Epping to Thornleigh Third Track Proposal. Application number SSI 5132.

I/we object to the Epping to Thornleigh Third Track Proposal and consider that the EIS is inadequate and does not address the full impact of this proposal. It will cause untold damage to the health of residents and to the fabric of the Beecroft Cheltenham Heritage Conservation Area. Do not approve this project, reconsider the alternatives and protect the community.

Figure S.6 Cross-section and elevation - New Cheltenham Station concourse building (see also S.5 for artist's impression)

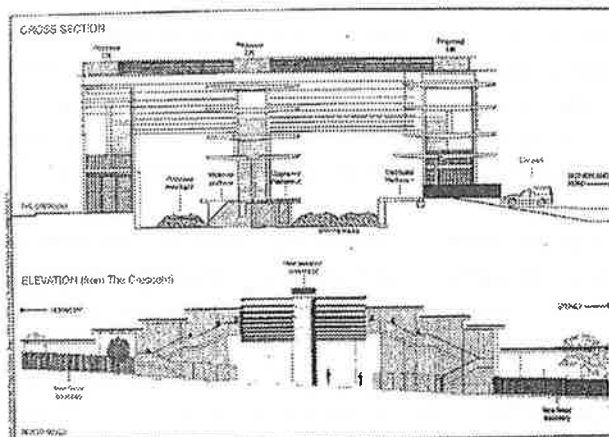
- The proposed redevelopment of Cheltenham Station shows no regard for the HCA. The visual impact of the proposed 13m high glass and steel concourse is totally unacceptable in this HCA.
